REF: N147950

DATE: 27 February 2020

**RE: MEADOWBANK EDUCATION AND EMPLOYMENT PRECINCT SCHOOLS PROJECT – SSD
18_9343 RESPONSE TO TRANSPORT RELATED SUBMISSIONS**

Response to Submissions

CAD FILE NO.
N147950-06-P1.DWG

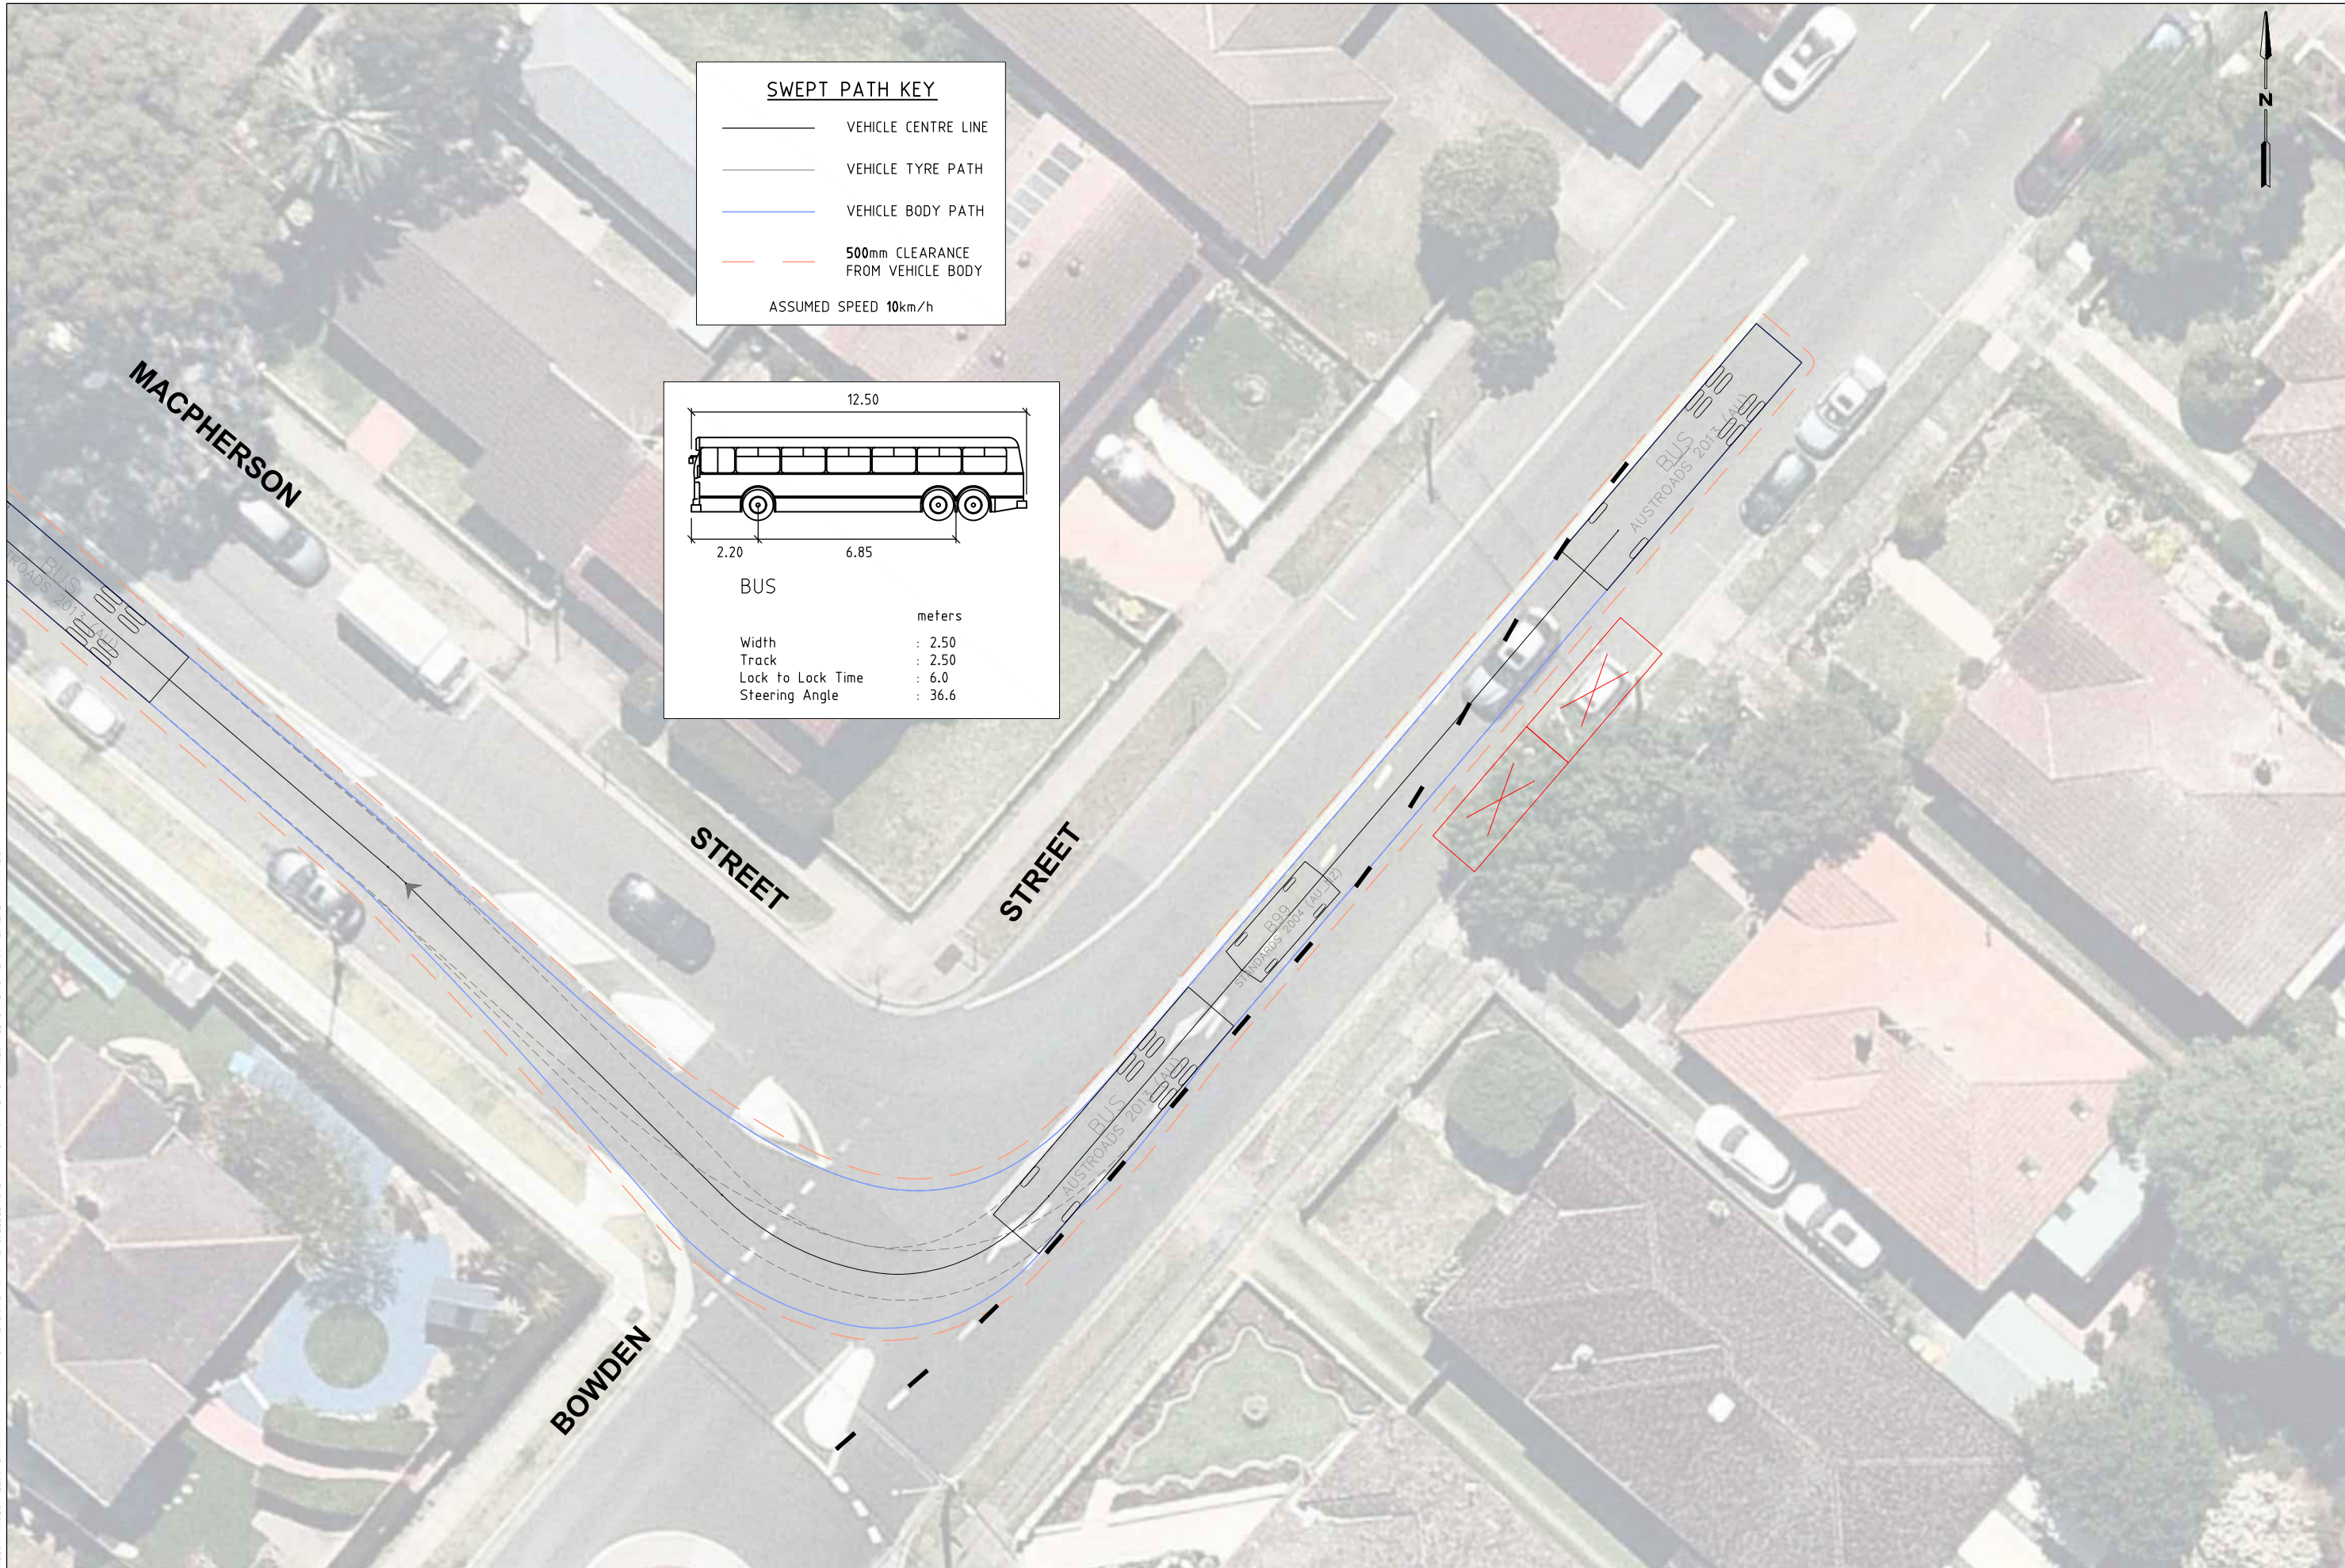
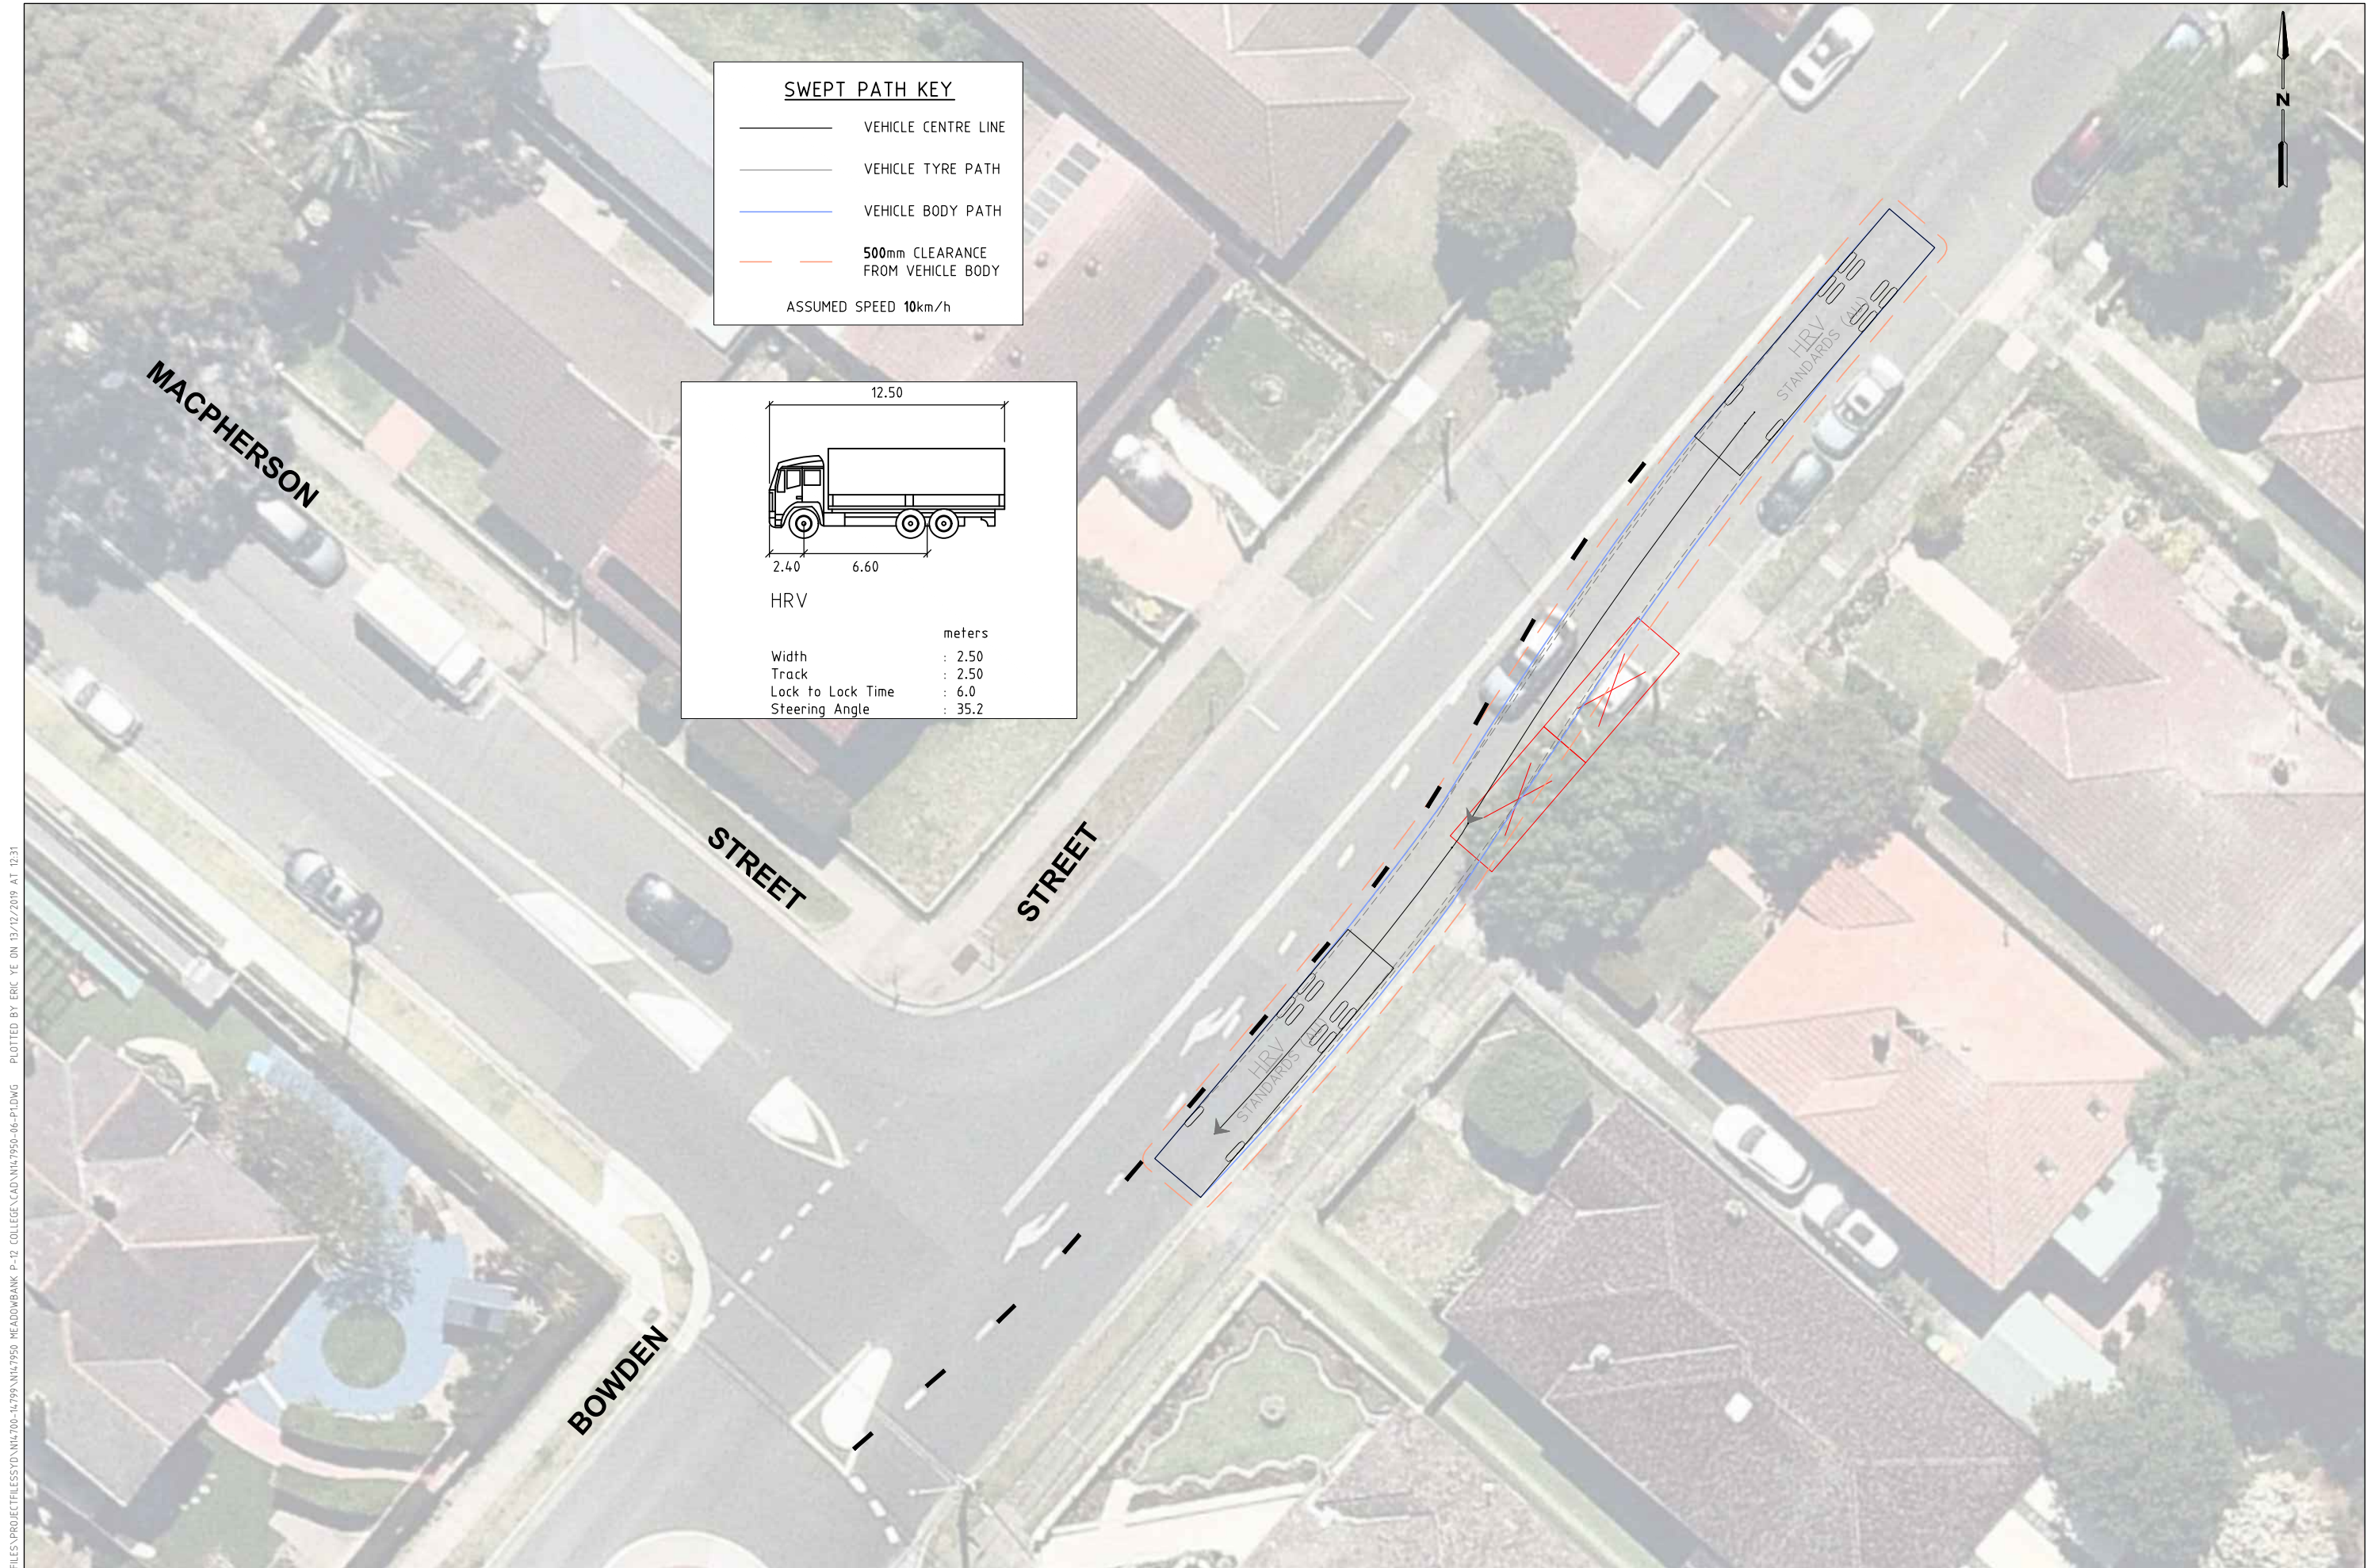
Comment 1: Swept path analysis should be provided for buses on all streets between Victoria Road and the proposed bus zone locations to ensure the surrounding streets are capable of accommodating the future school bus services. Turnaround facility on Rhodes Street with access for all services via Hermitage Road should also be considered to better facilitate the future traffic generating from the school sites. The proposed length and allocation to Primary school of a bus zone on Rhodes Street should also be further reviewed for servicing the proposed two school bus stops. Clarification should also be provided on how the works will be delivered.

GTA response: A swept path assessment has been completed for the likely 12.5 metre bus on approach and departure between the site and Victoria Road and shown in Attachment 2. It is noted that the proposed bus route (particularly Rhodes Street and Hermitage Road) is already a heavy vehicle access route for the existing industrial area.
